**WELWYN HATFIELD BOROUGH COUNCIL
EXECUTIVE DIRECTOR - PLANNING, PUBLIC PROTECTION AND GOVERNANCE**

DELEGATED APPLICATION

Application No: 6/2020/1740/PN8
Location: 86 Bell Lane Hatfield AL9 7AY
Proposal: Erection of single storey rear extension to the rear of the original rear of the building
Officer: Mr Tom Gabriel

Recommendation: Refused

Proposed Block Plan

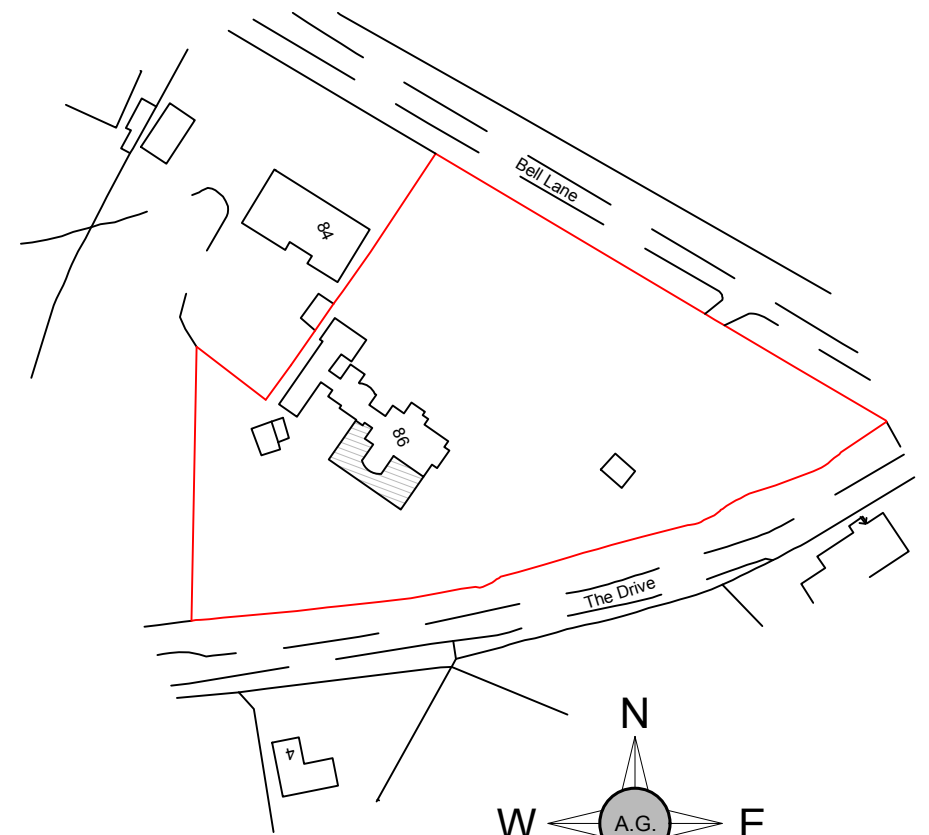
On this basis, the deepest part of the proposed extension would be 8.5m, greater than the permitted 8m. Moreover, the extension would extend beyond a wall forming a side elevation of the original dwellinghouse and would exceed half the width of the dwellinghouse. Consequently, the proposal would fail to comply with paragraphs (g)(i) and (j)(iii) of Schedule 2, Part 1, Class A of the Town and Country Planning (General Permitted Development) (England) Order 2015 as amended.

1. The deepest part of the proposed extension would be 8.5m and the extension would extend beyond a wall forming a side elevation of the original dwellinghouse and would exceed half the width of the dwellinghouse. Consequently, the proposal

would fail to comply with paragraphs (g)(i) and (j)(iii) of Schedule 2, Part 1, Class A of the Town and Country Planning (General Permitted Development) (England) Order 2015 as amended.

Rear Elevation  
As Proposed - Scale 1:100

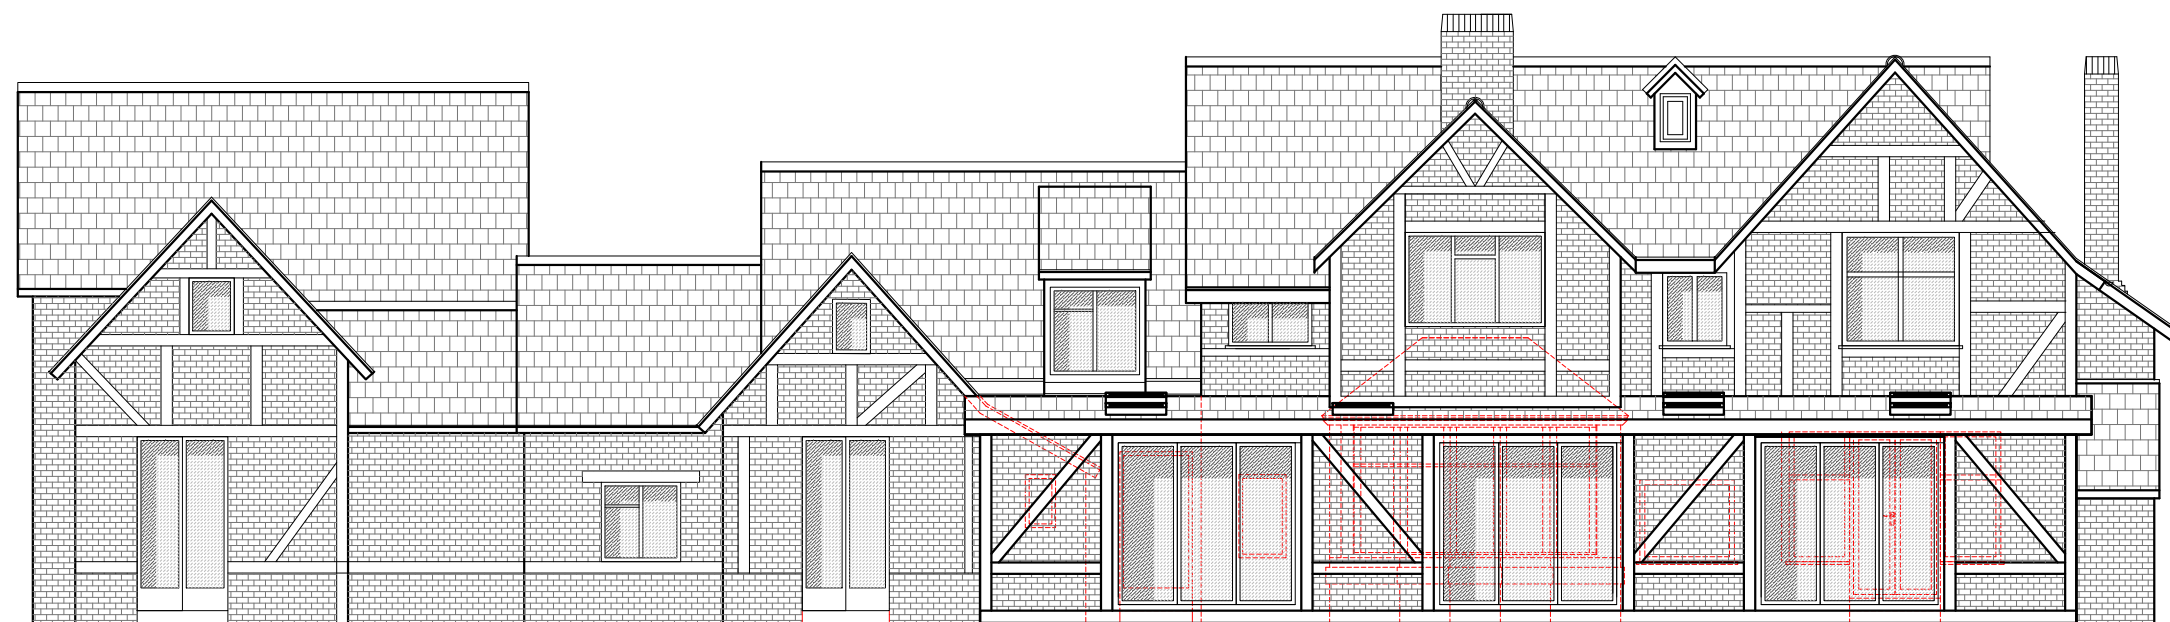
- The applicant has not confirmed that the external walls of the extension would be of a similar appearance to those used in the construction of the exterior of the existing dwellinghouse. Consequently, the development would not accord with condition A.3(a) of Schedule 2, Part 1, Class A of the Town and Country Planning (General Permitted Development) (England) Order 2015 (as amended).
